Recommendation Report for Planning Permission for Works or Extension to a Dwelling

REF NO: AW/52/21/HH

LOCATION: 59 Carlton Avenue
Aldwick
PO21 3LP

PROPOSAL: Conversion of roof space to habitable use to include 3 x side dormers including raising of roof.

Proposed Plans and Elevations

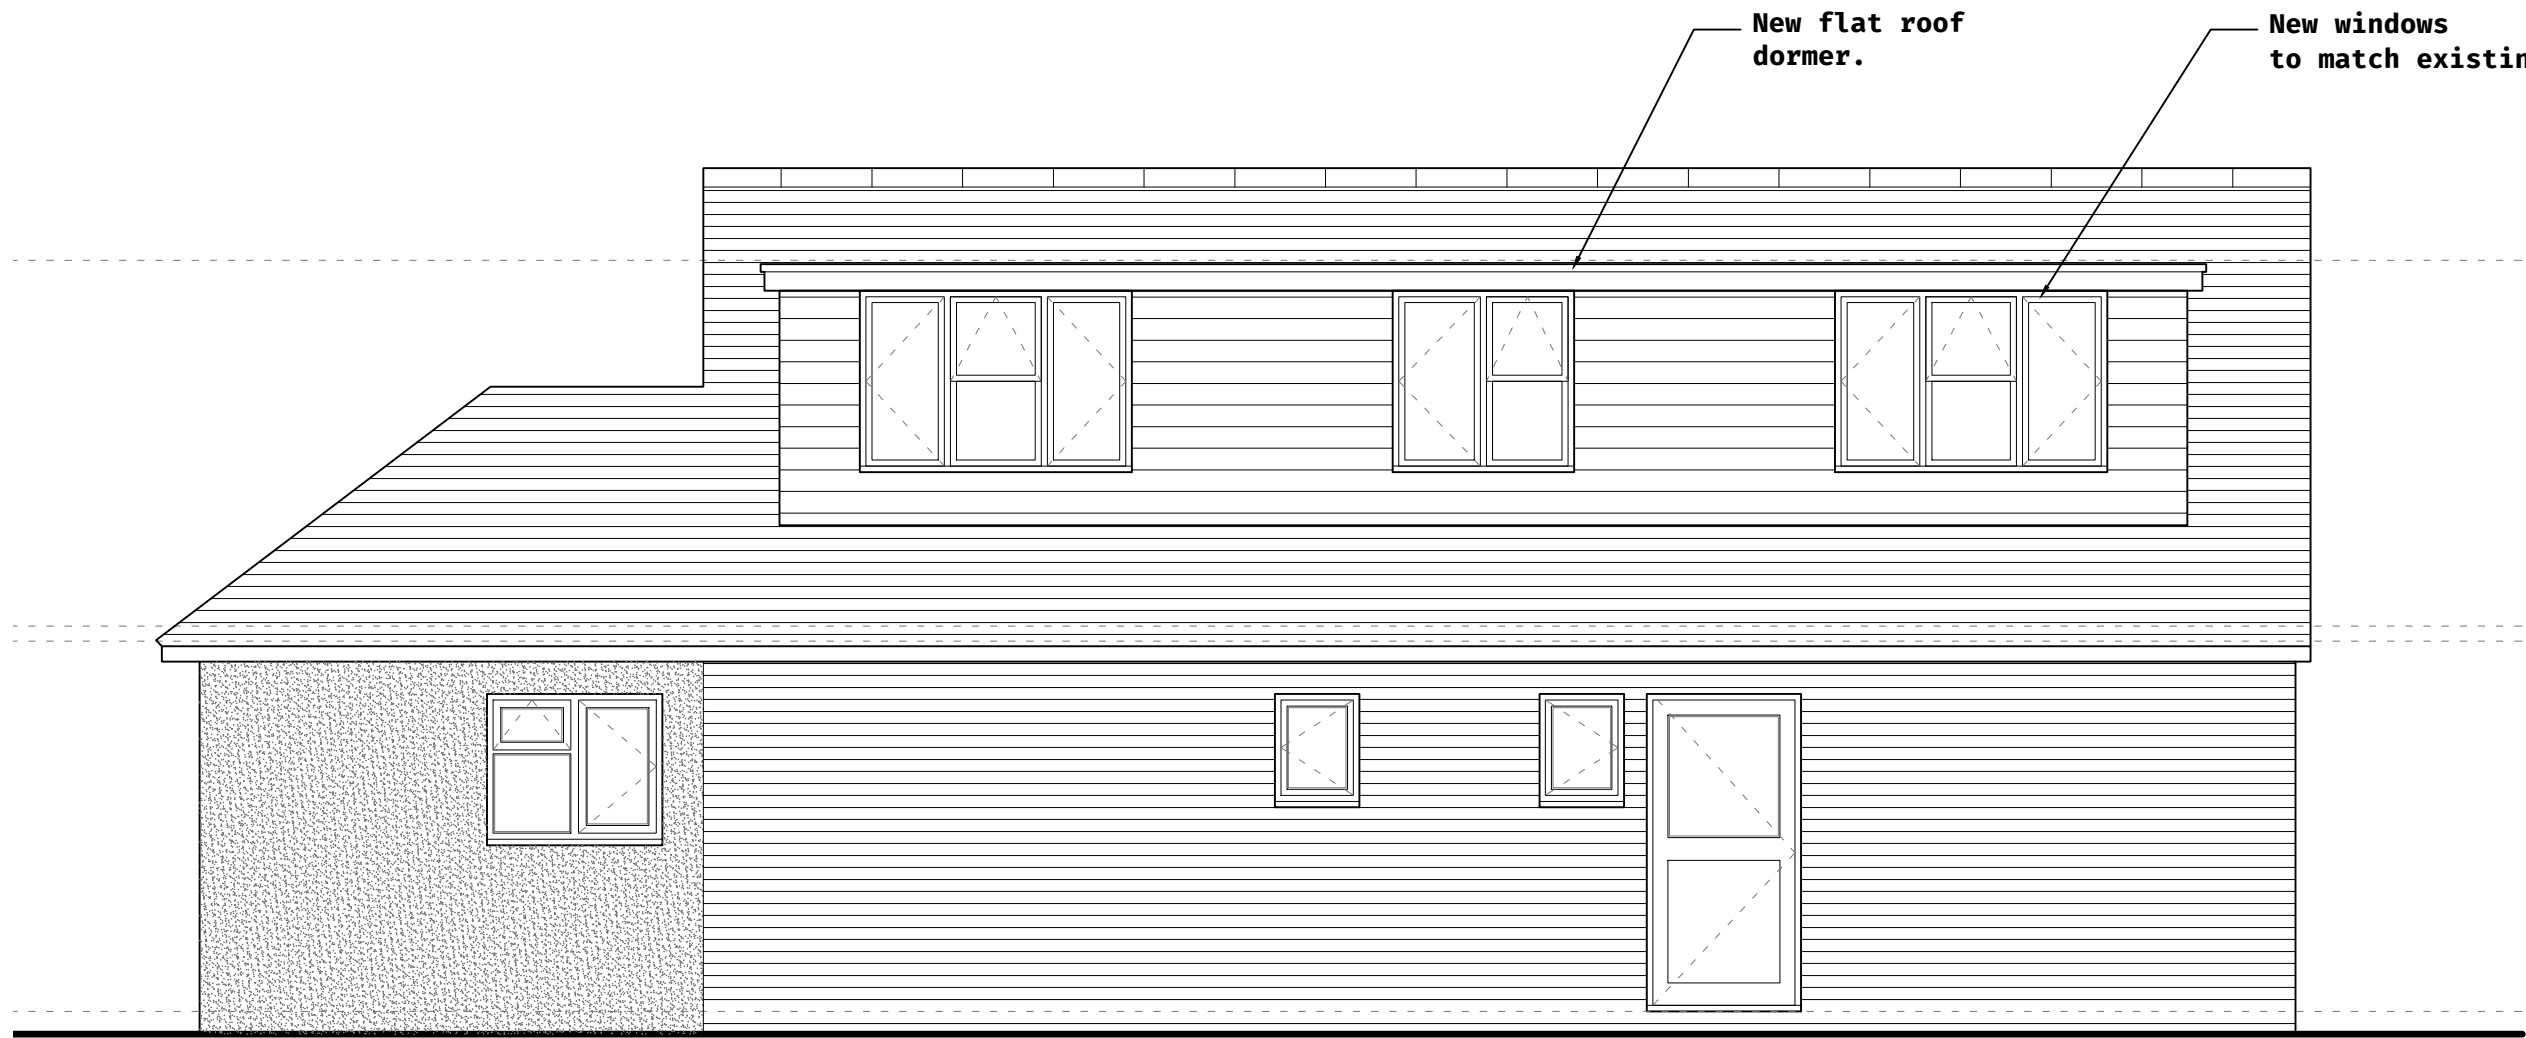
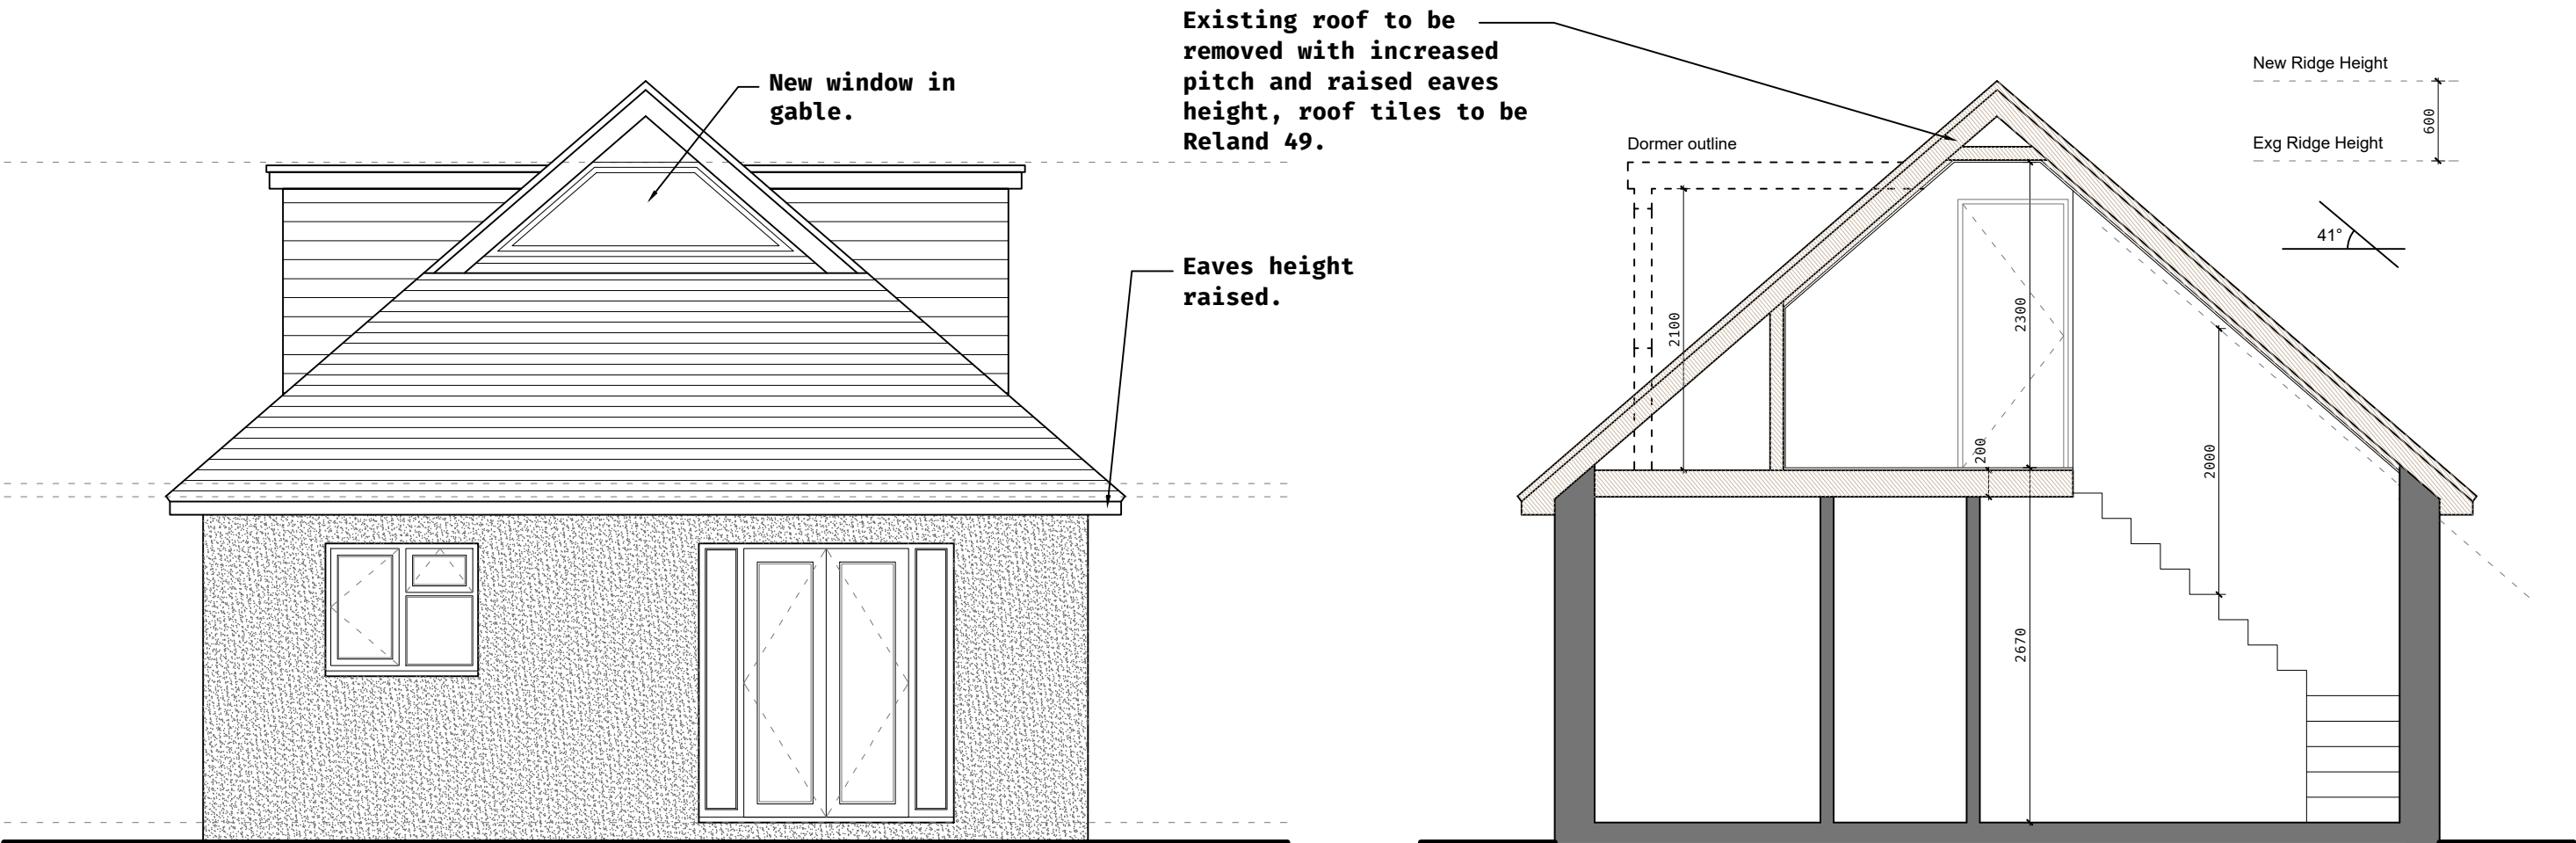
The surrounding properties are mixed in appearance and the dormer is not considered to appear unduly dominant, with the dormers set back around 0.85m from the front elevation.

The dormers will have horizontal boarding to match the host dwelling and will have a flat roof 0.8m below the pitch height of the existing dwellinghouse.

The dormers will be located to the northern and southern elevations of the dwelling. These will have a height of around 1.7m and a depth of 2.1m. To the northern elevation there will be one larger dormer which will have a width of approximately 9.3m. To the south there will be two smaller dormers which will both have a width of approximately 2.9m.

The proposal includes a dormer and conversion of the roof space to habitable use. The dormer whilst being a large addition it falls under the permitted development rights of the property where they could be erected without requiring planning permission. There will be potential overlooking of the neighbouring property however a condition will be imposed to prevent this from happening.

Reason: To comply with Section 91 of the Town and Country Planning Act 1990 (as amended).
- 2 The development hereby approved shall be carried out in accordance with the following approved plans:
 - Location Plan 2021/01/011
 - Existing Plans 2021/01/001
 - Proposed Plans 2021/01/010
Reason: For the avoidance of doubt and in the interests of amenity and the environment in accordance with policy D DM1 of the Arun Local Plan.
- 3 The dormer windows and rooflights on the side elevations of the building at first floor level shall at all times be glazed with obscured glass and fixed to be permanently non-opening below 1.7m internal floor level.
